Friday, 23 September 2022

Narromine Shire Council

Response to Preferred Infrastructure and Amendment Report
State Significant Infrastructure

Inland Rail- Narromine to Narrabri SSI-9487

Figure A7.9 Level crossings (map 1)

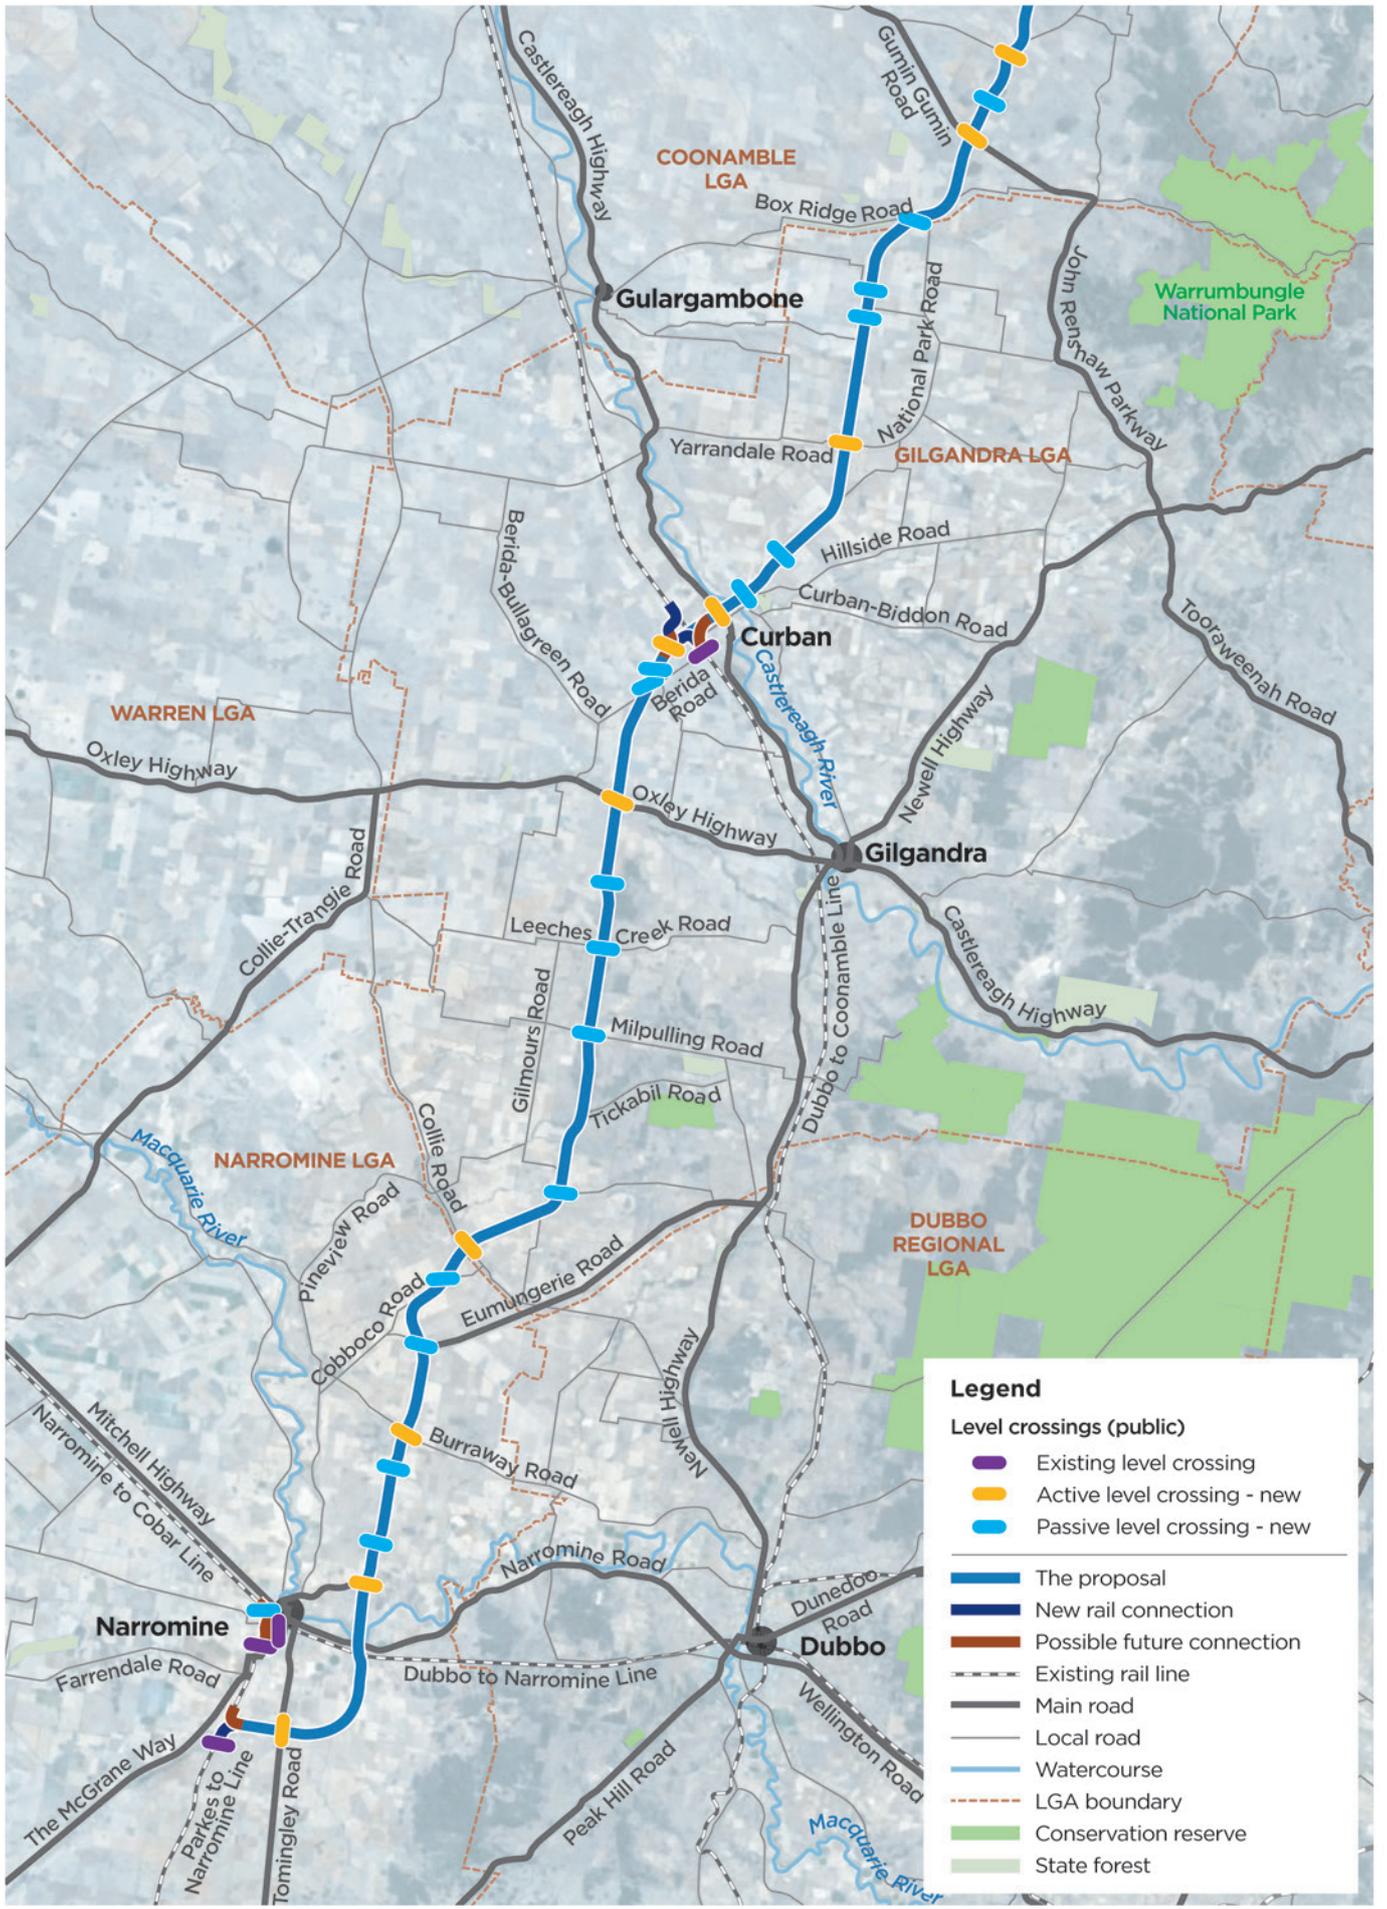
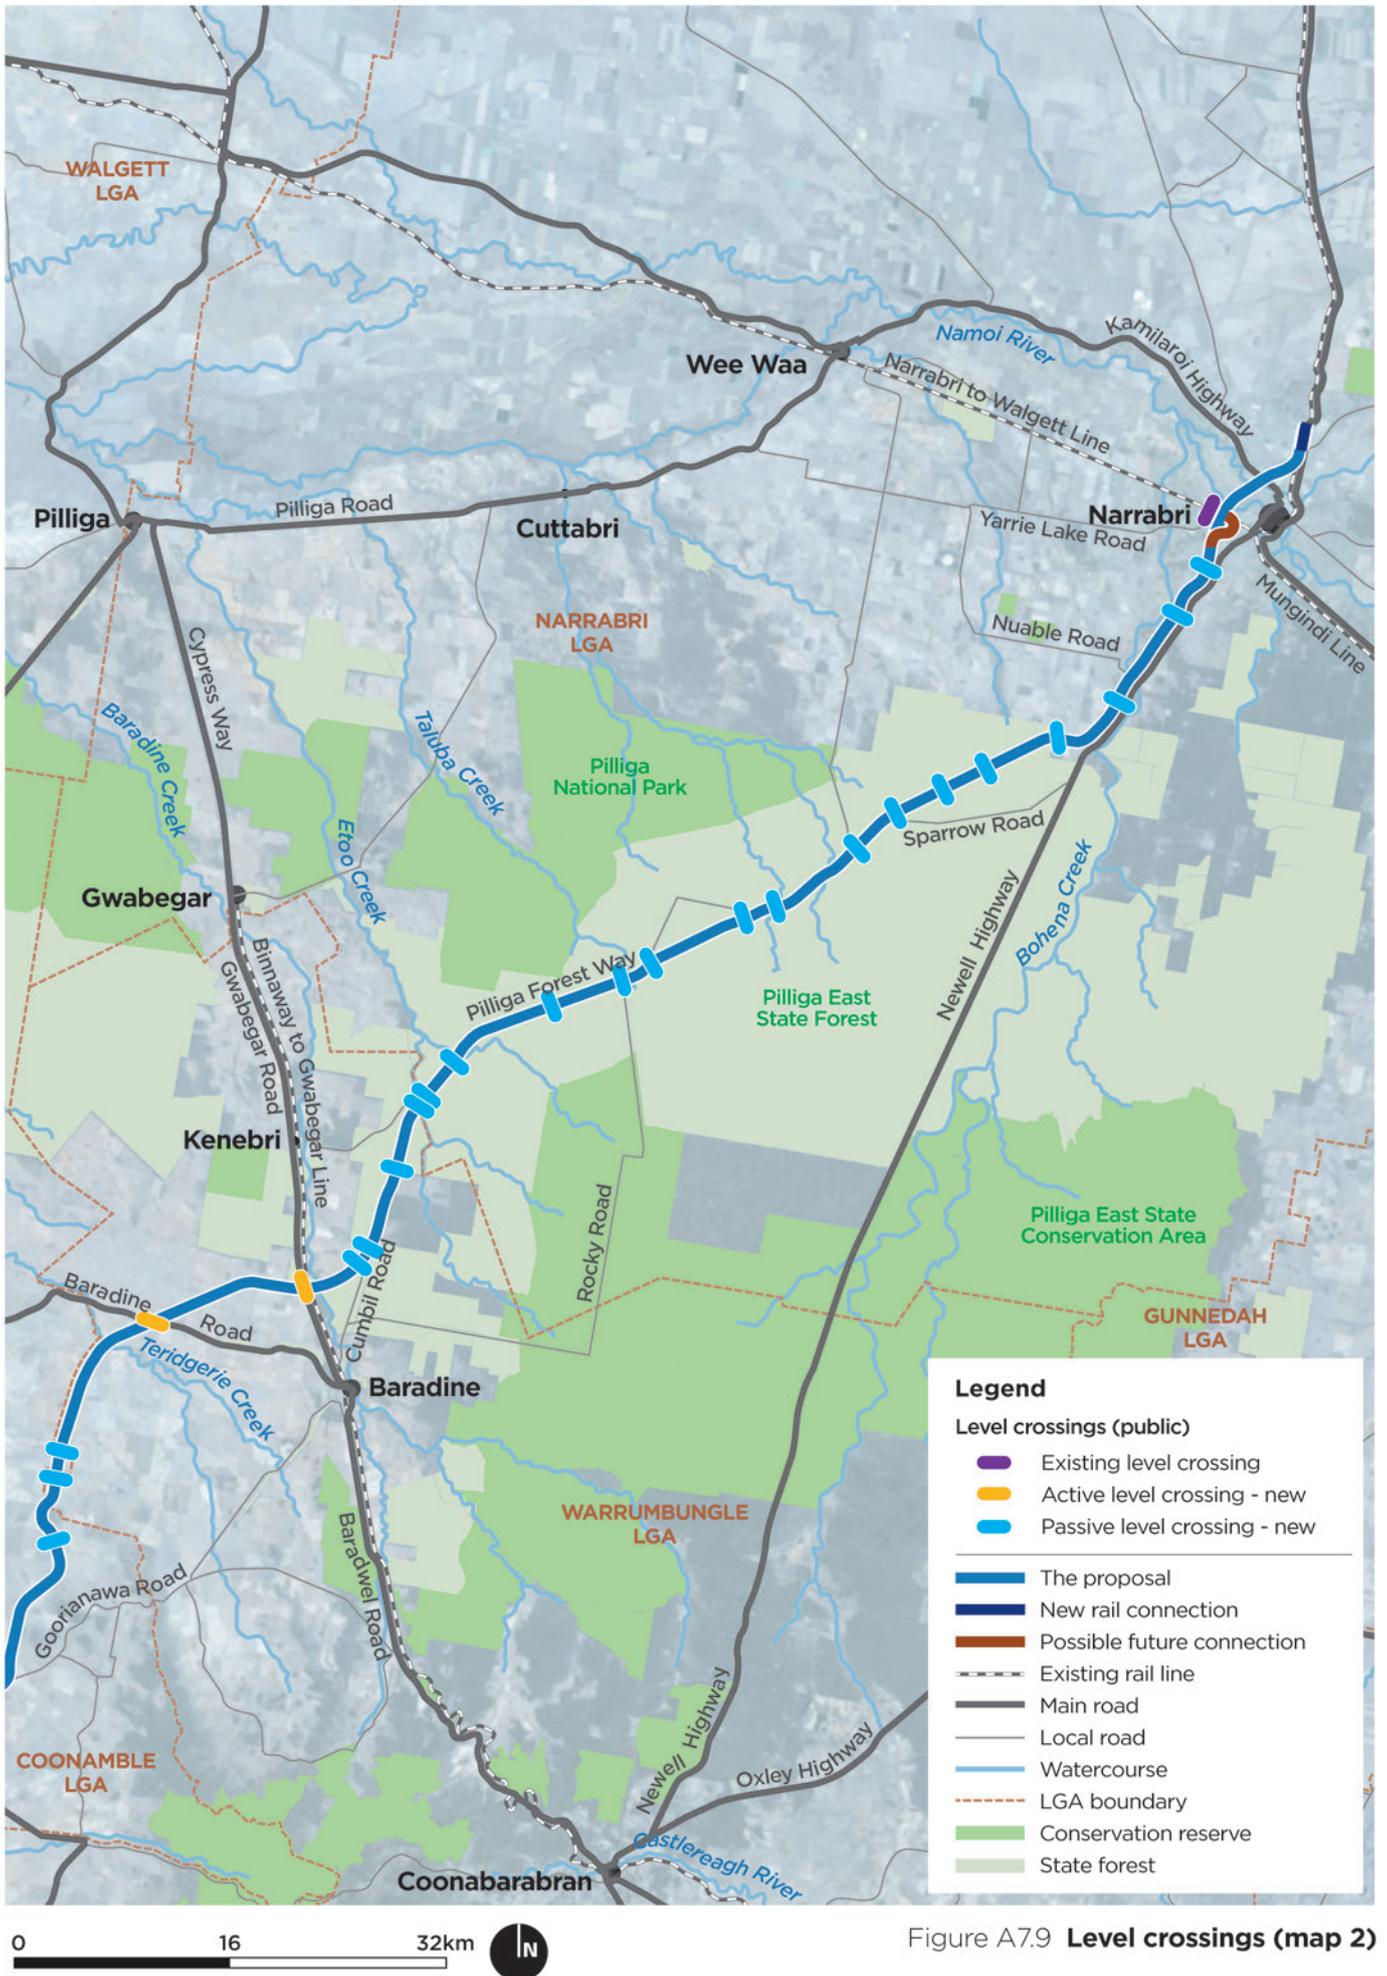
Council maintains its strong objection to the construction of such a significant number of passive level crossings in a direct contravention of the stated policy positions of not only the Office of National Safety Regulator (ONSNR) and Transport for NSW but of ARTC itself.

Council is aware of lower cost, hazard reduction systems that should be considered for inclusion within the design requirements.

Council requests that as a condition of consent the proponent is required to provide a minimum of solar powered lighting systems on all passive level crossings.

Council further requests the inclusion in the Level Crossing Report (LCR) for the Project infrastructure, a detailed safety and cost analysis for the inclusion of proximity-based Level Crossing Warning Systems such as the Safety Integrity Level (SIL) 2 rated Wavetrain acoustic detection system currently in use within the Australian Pilbara region.

Figure B2.1 **Proposed bore field locations**
(map 1)

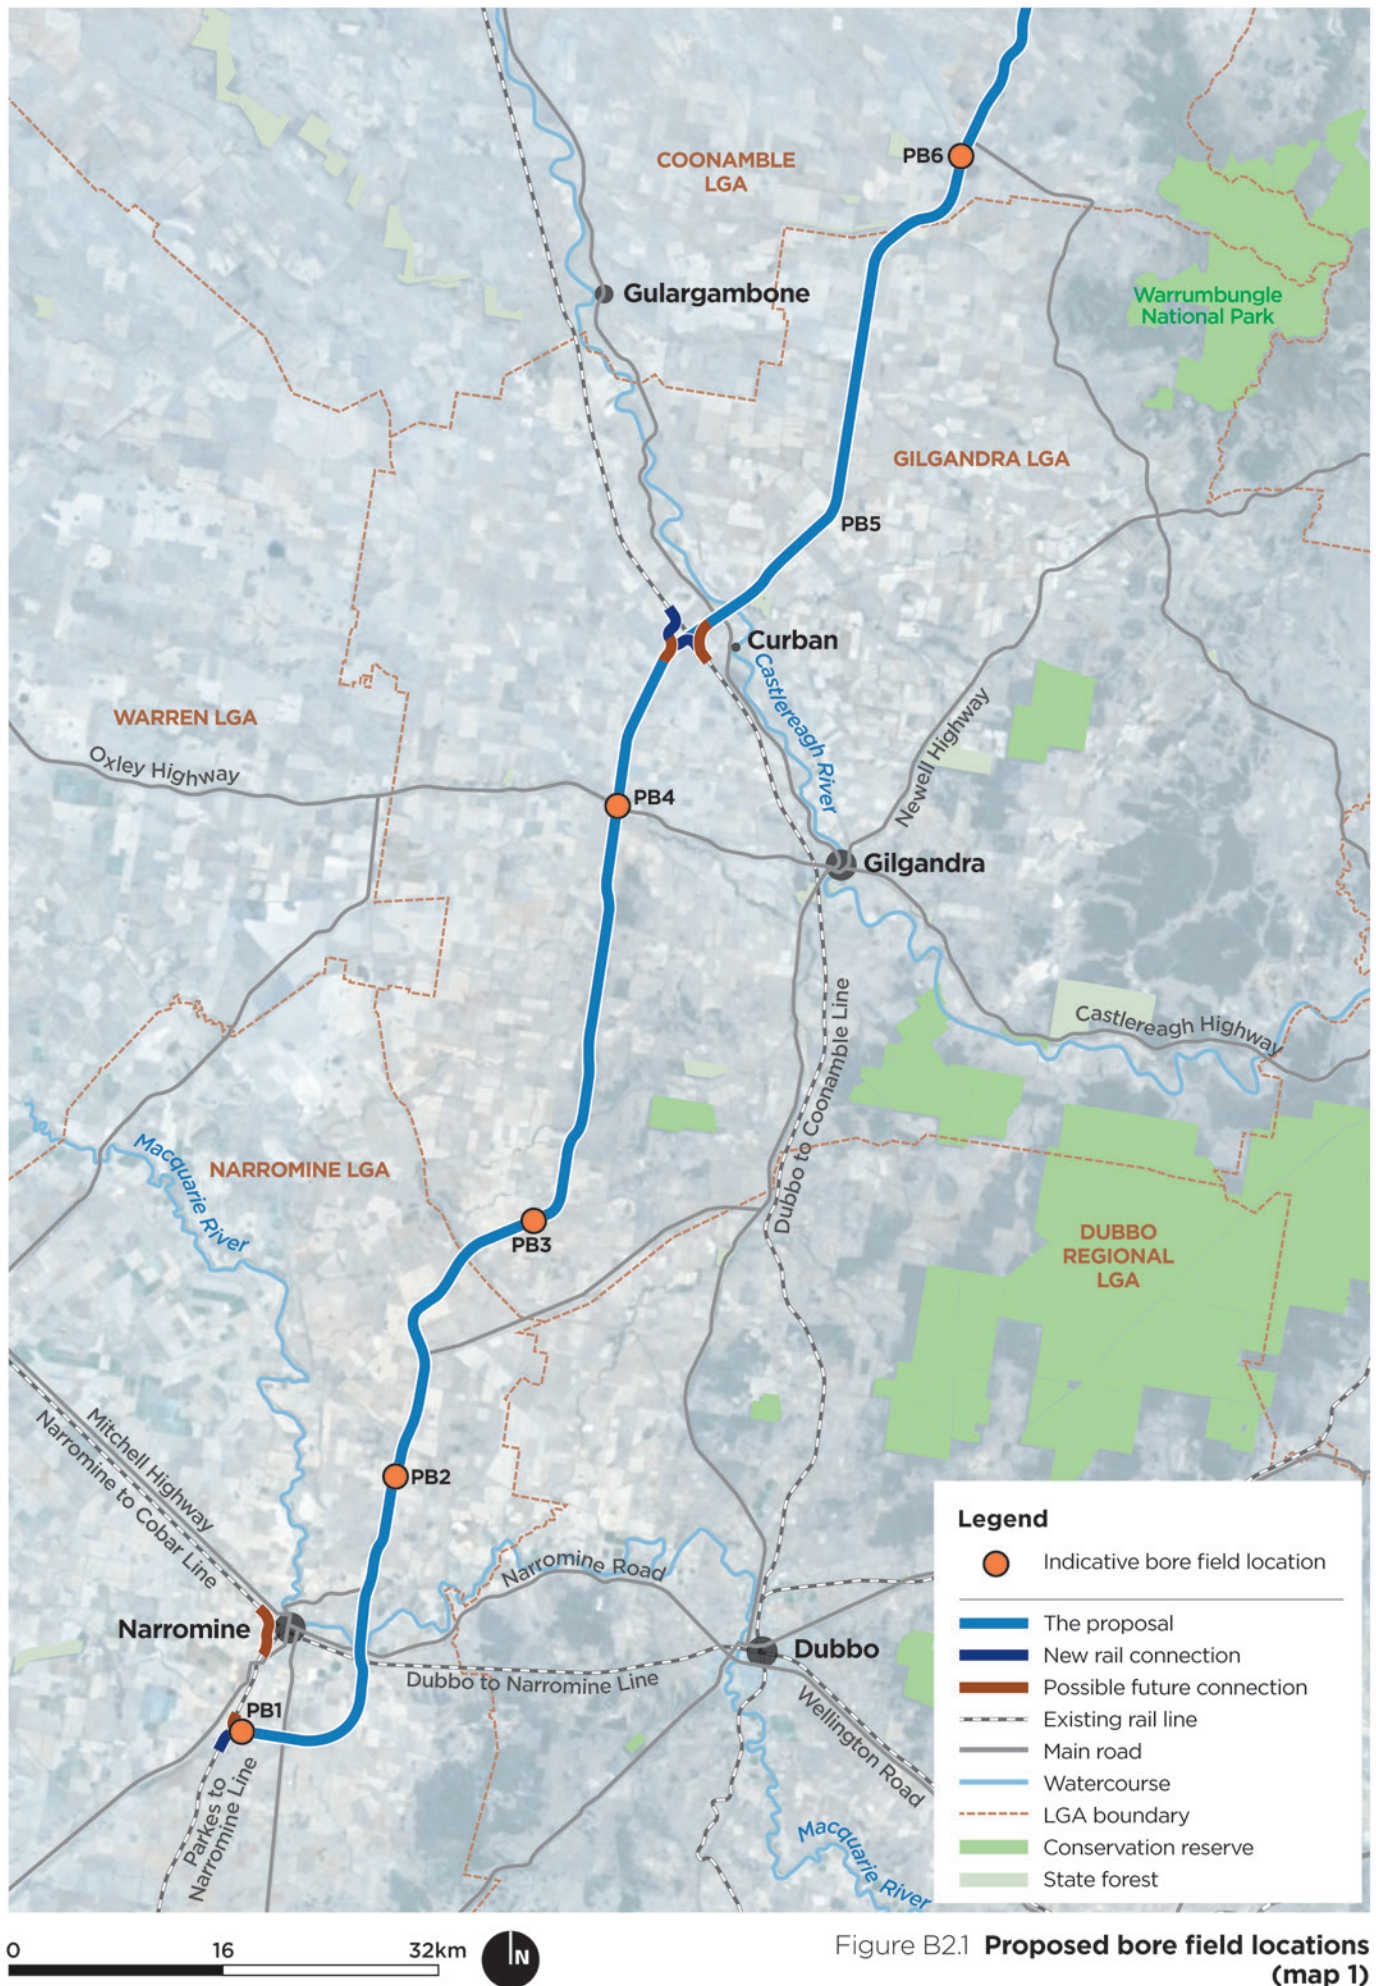
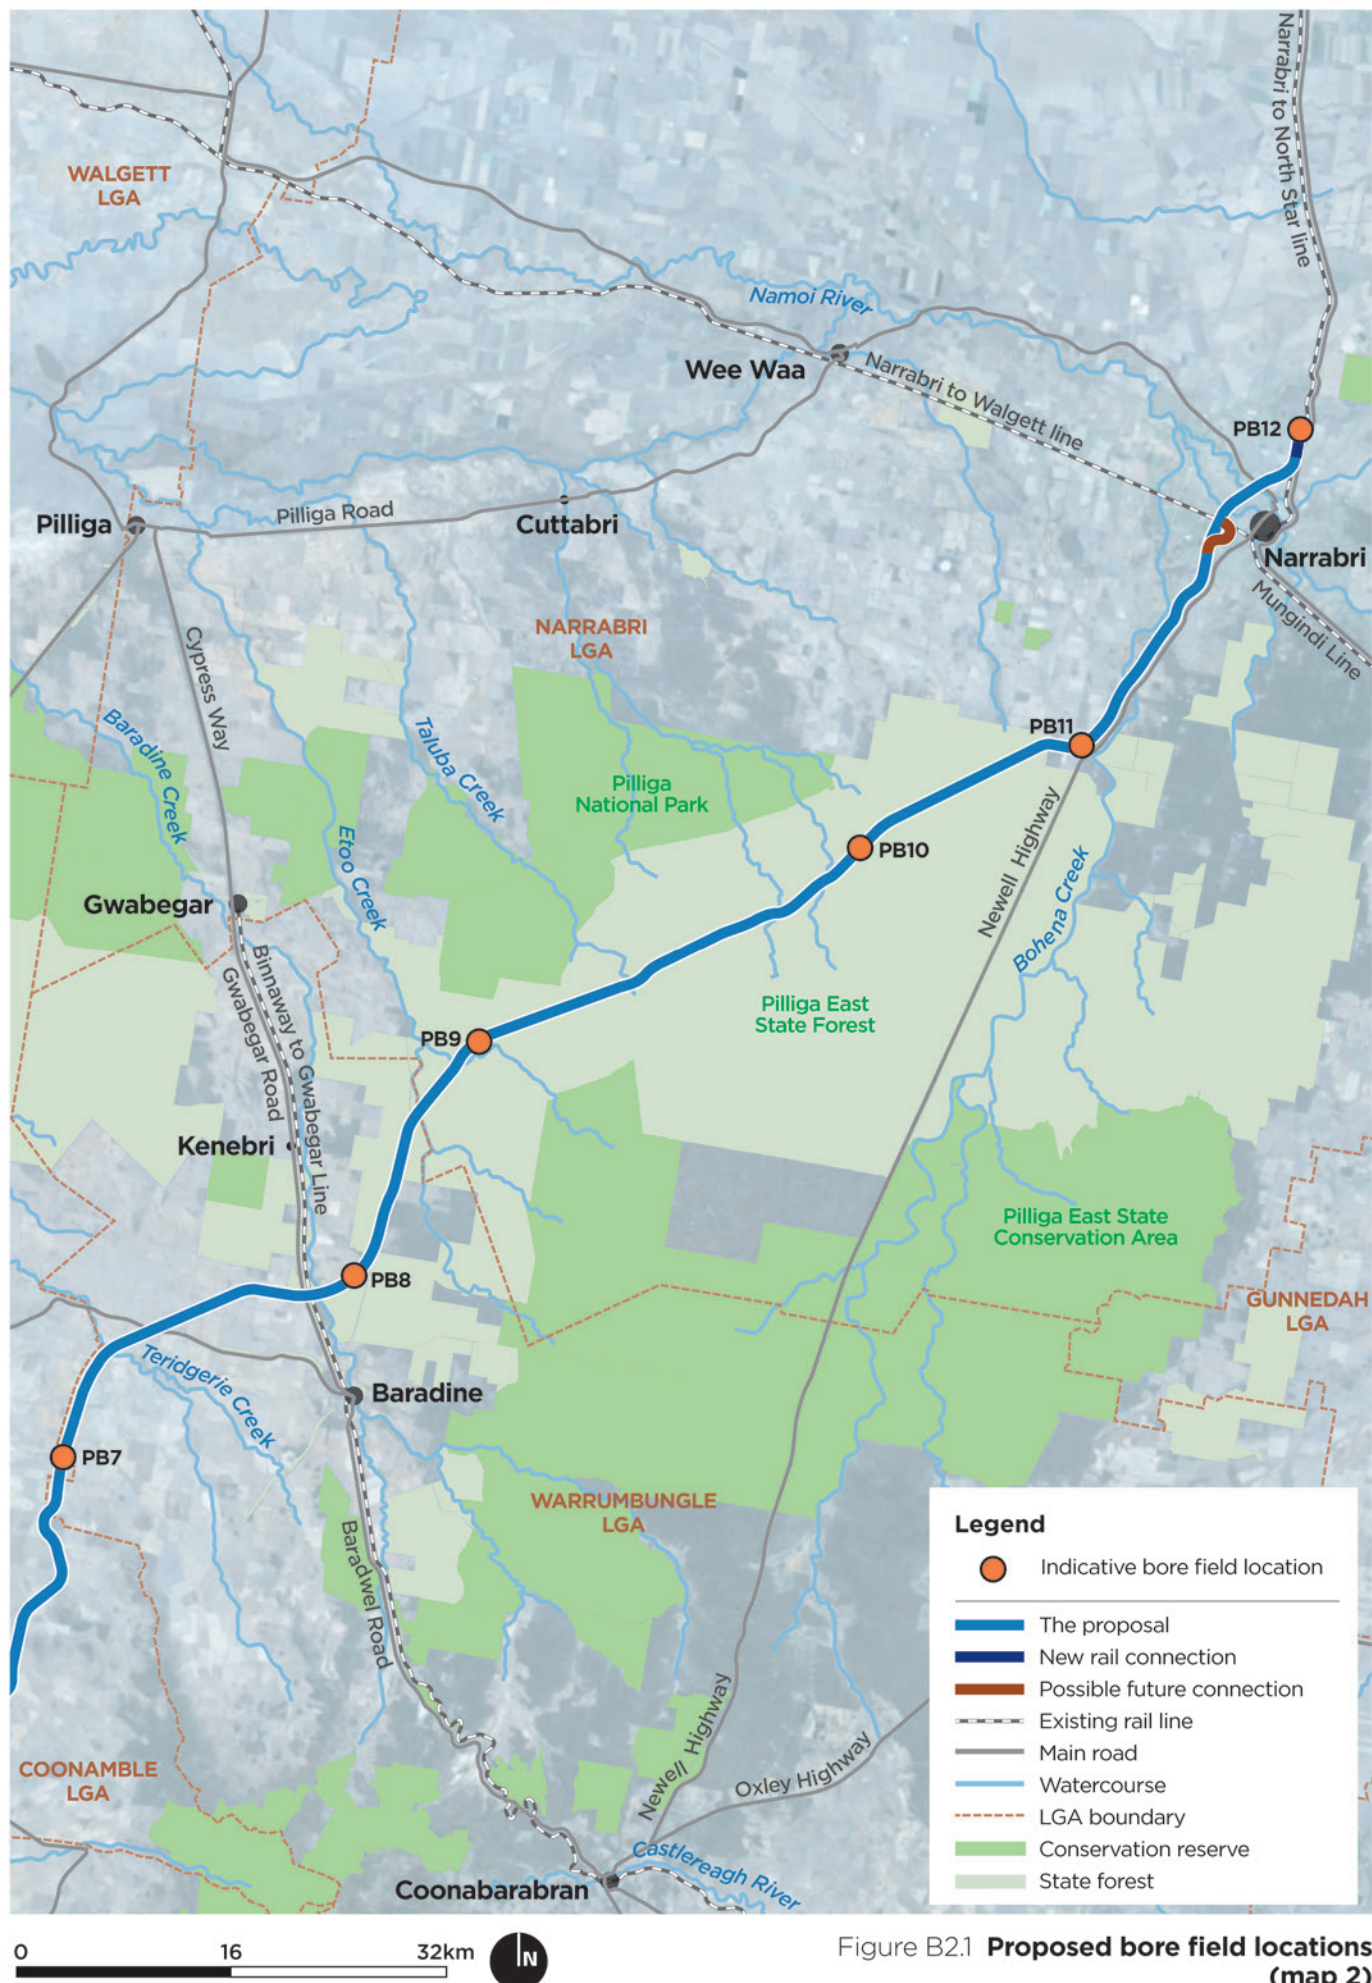
Council requests the Bore Field Management Plan to be prepared as part of the Soil and Water Management Plan be made public as soon as practical to allow existing licensed groundwater users to better understand the likelihood of aquifer interference impacts. This is especially important if the targeted water sources differ from those already nominated and
